2024/90235 (condition 10)

2024/90236 (condition 11, 12 & 14)

2024/90237 (condition 03, 04, 05, 06, 07, 09 & 18)

PROPOSED CONSTRUCTION SITE PLAN SCALE 1:125 @ A1

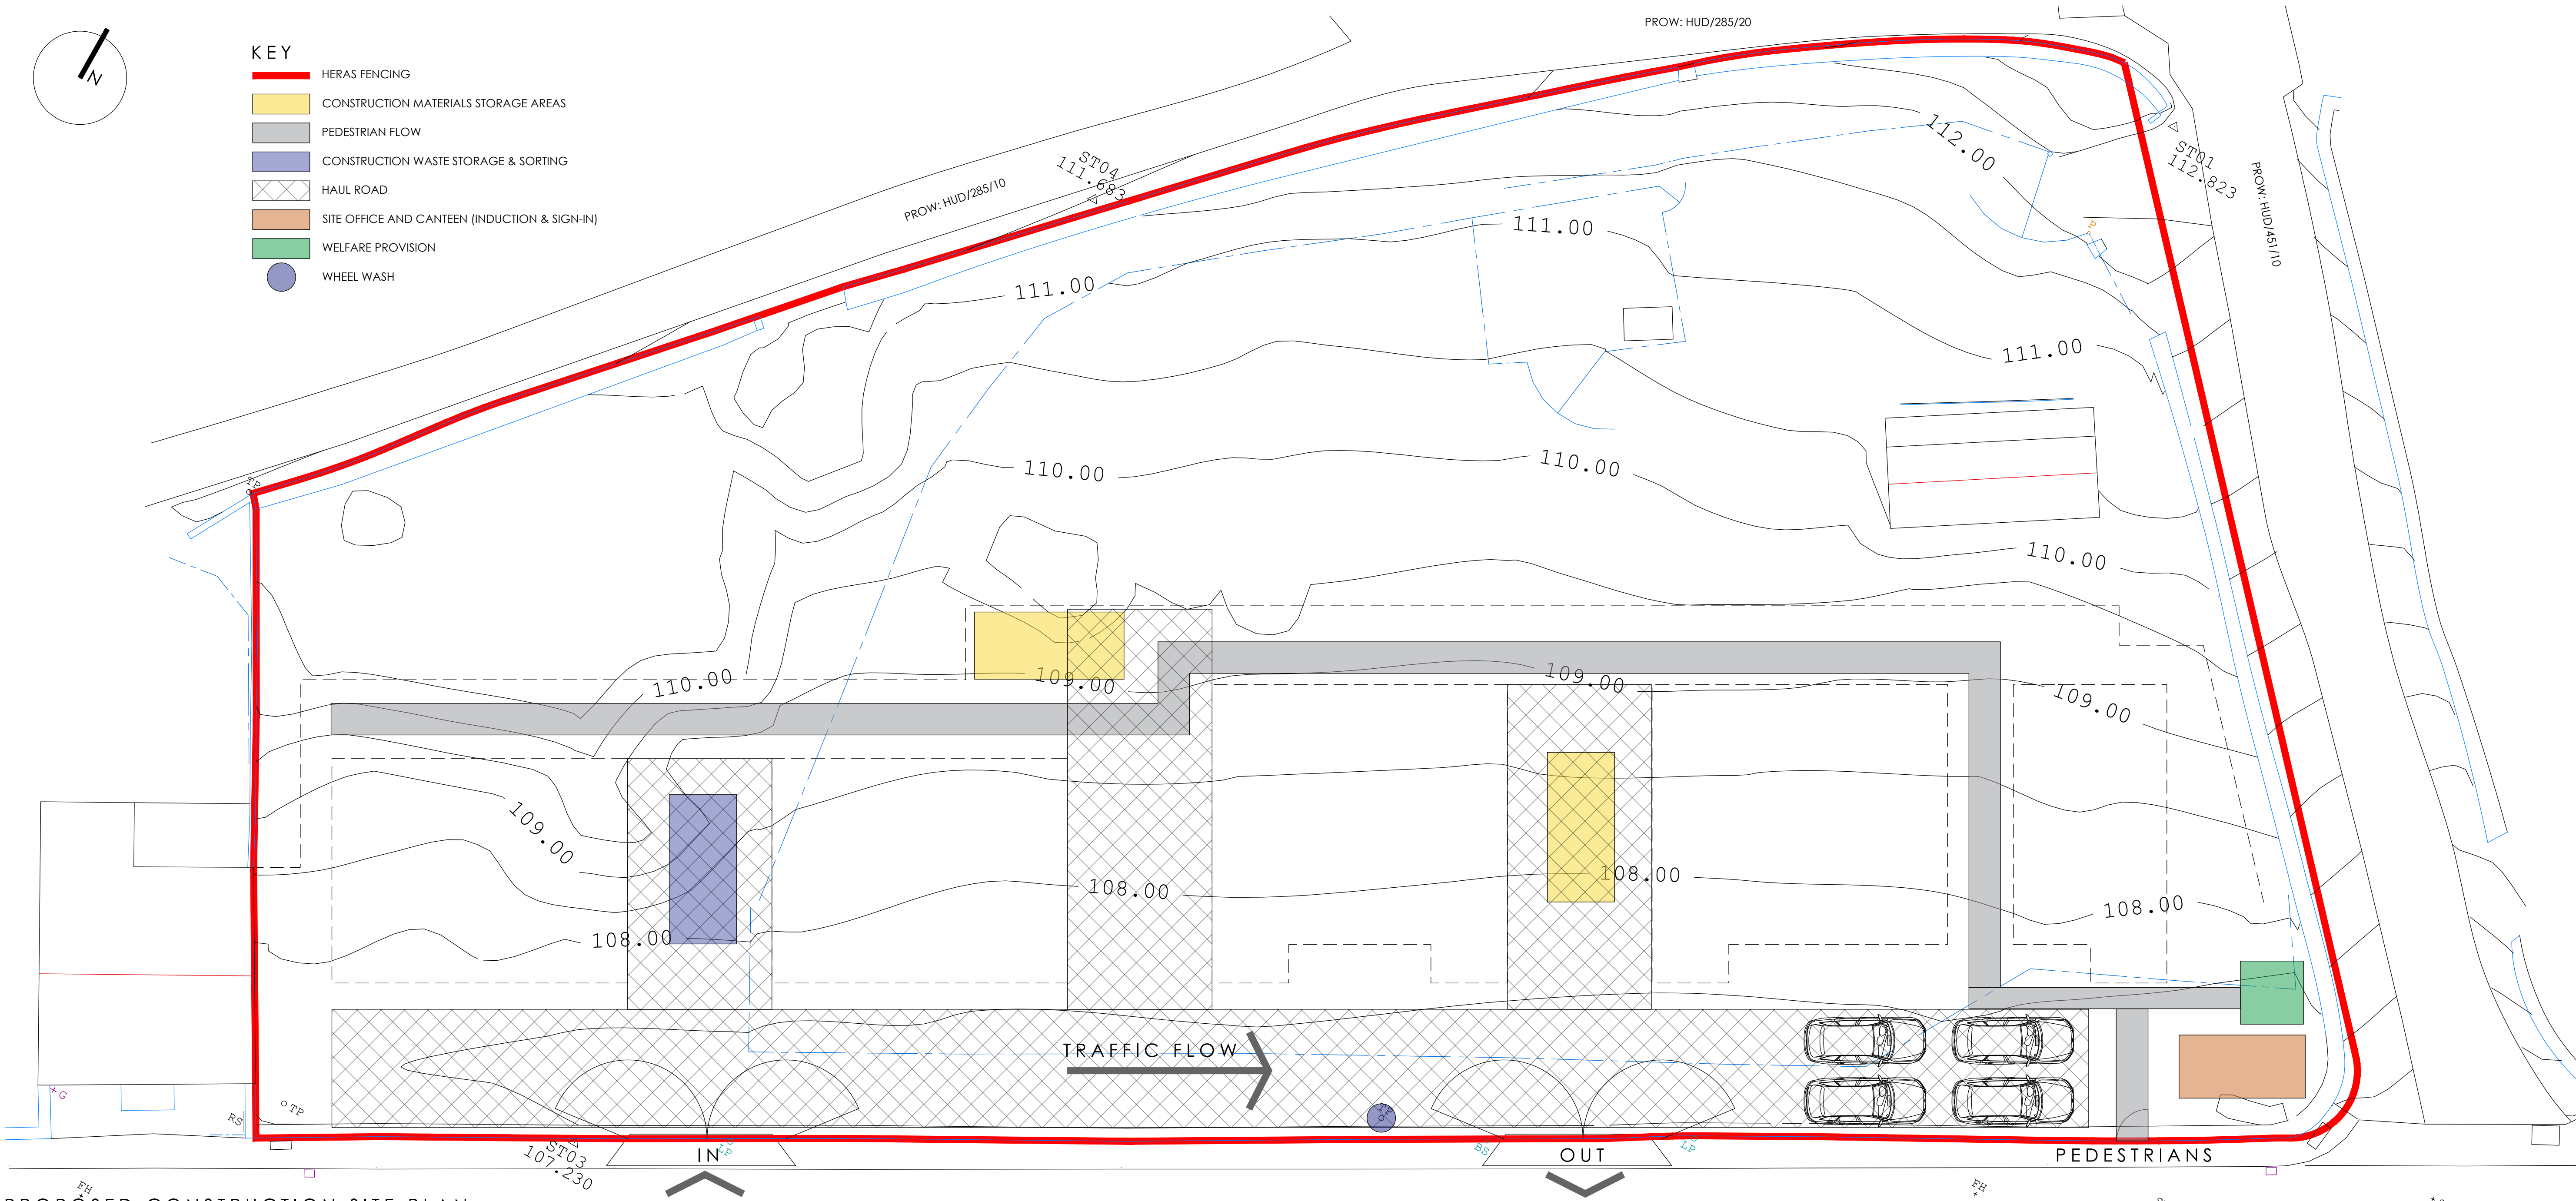
- Hours of work: Oppose Saturday working until 1800. Advise this should be 1300, unless specific justification for a longer period is provided.
- Construction vehicle sizes and routes: No details of size or routing provided. Routing means to the site, not within. The route should avoid difficult local roads, such as Dodlee and Longwood Gate. Approaching from the north / west in general should be avoided, with a route via Milnsbridge being most suitable.

- Location of HGV waiting areas and details of their management: Consideration should be given to unloading within the site. If not feasible, this should be demonstrated. If on-road is needed, the location should be shown on plan along with evidence that it would be safe (i.e., not affecting sightlines, blocking junctions, bus movements).

- Parking for construction workers: 4 spaces is limited and parking on Britannia Road. Can 4 additional spaces not be provided to the left of the in point as well? If not, as above if on-road is needed, the location should be shown on plan along with evidence that it would be safe (i.e., not affecting sightlines, blocking junctions, bus movements).

- Measures to be taken to minimise the deposit of mud, grit and dirt: Confirmation of water discharge point for cleaning should be provided: muddy / silty water discharging onto the highway is a cause for concern. Also, it is stated that 'Drivers will check their wheels...'. Given that deliveries from 3rd parties will take place, therefore not necessarily being aware of this requirement, it should be the responsibility of the site manager to check and ensure wheels are clean.

- condition 3 (CEMP). timescale: prior to commencement.
- Please refer to Appendix A (rev A) & drawing 23035-104 rev A - PLANNING CEMP which have been updated to reflect the above requests.
